KITTITAS COUNTY DEPARTMENT OF PUBLIC WORKS

MEMORANDUM

TO: Scott Turnbull, Community Development Services
FROM: Christina Wollman, Planner II
DATE: November 27, 2006
SUBJECT: Hatlestad Short Plat

Our department has reviewed the Plat application and has the following comments:

HATLESTAD SHORT PLAT
PART OF SECTION 16, T. 18 N., R. 18 E., W.M.
KITITAS COUNTY, WASHINGTON

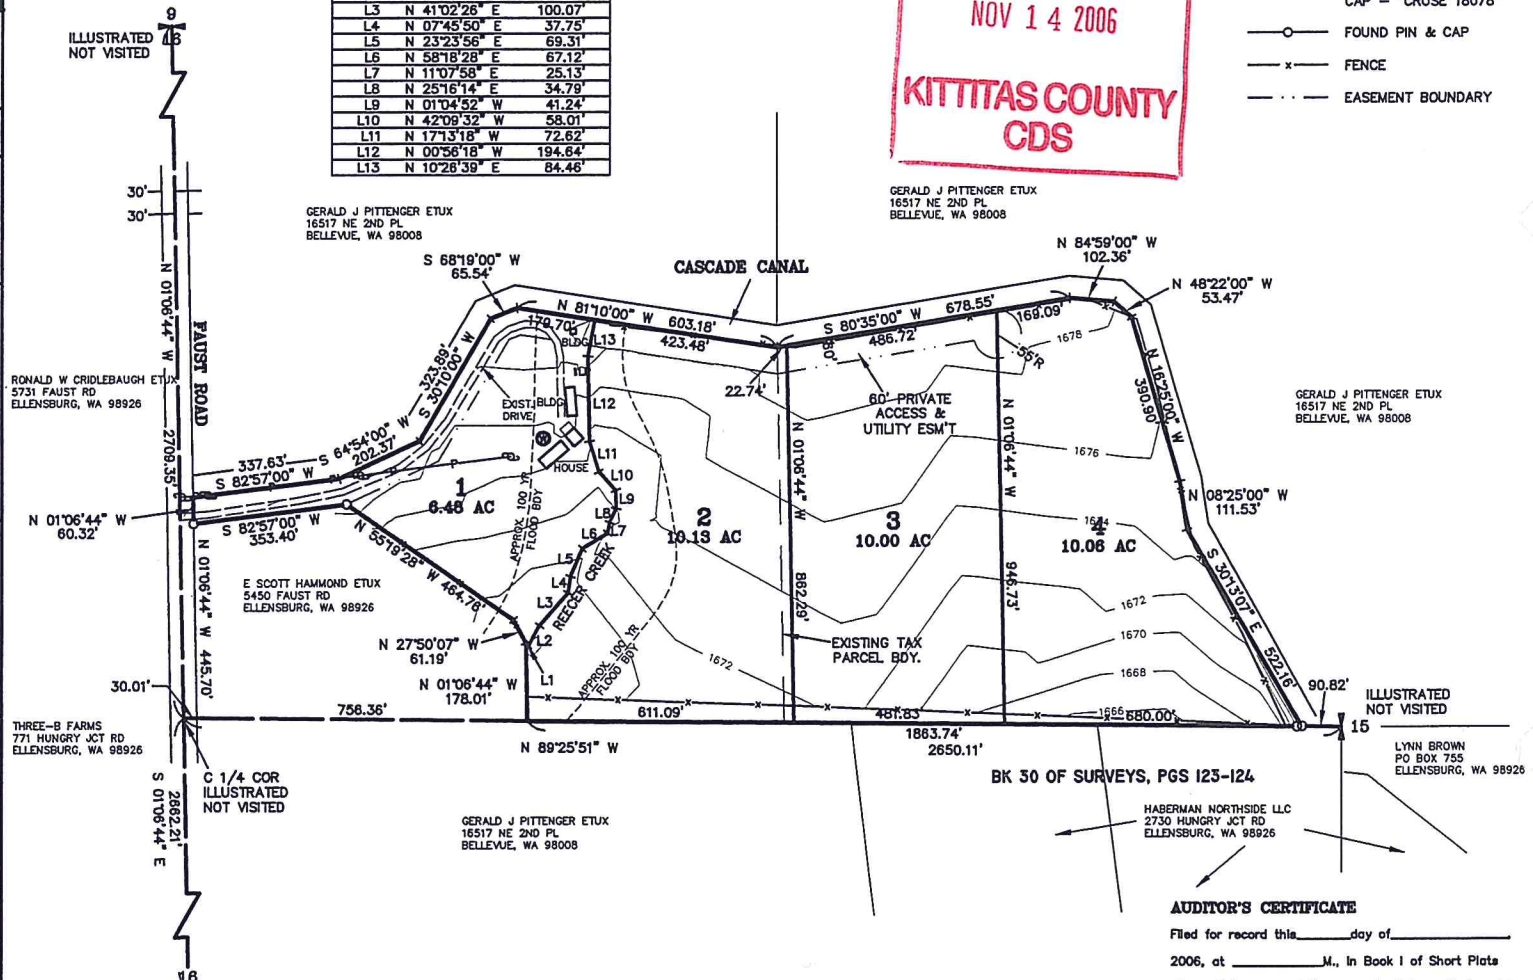
4. Private Road Improvements: Access from Faust Road shall be constructed as a Low-Density Private Road. See Kittitas County Road Standards, 9/6/05 edition.

- a. Access easements shall be a minimum of 60' wide. The roadway shall have a minimum width of 20', with 1' shoulders, for a total width of 22'.
- b. Minimum centerline radius will be 60'.

- c. The surface requirement is for a minimum gravel surface depth of 6".
- d. Maximum grade is 12%.
- e. Stopping site distance, reference AASHTO.
- f. Entering site distance, reference AASHTO.

- j. All easements shall provide for AASHTO radius at the intersection of Faust Road.
- k. A paved apron shall be constructed at the intersection of the proposed private intersection and Faust Road.

5. Cul-de-Sac: Permanent deadend streets shall have a turn-around having an outside right-of-way easement diameter of at least 110' (55' radius) at the closed end. See Kittitas County Road Standards, 9/6/05 edition.

6. Driveway – Single Access: Access from the private road to Lots 2, 3 and 4 shall meet or exceed the conditions of a single access driveway. See Kittitas County Road Standards, 9/6/05 edition.

- a. The roadway shall be a minimum of 8' wide with gravel surface.
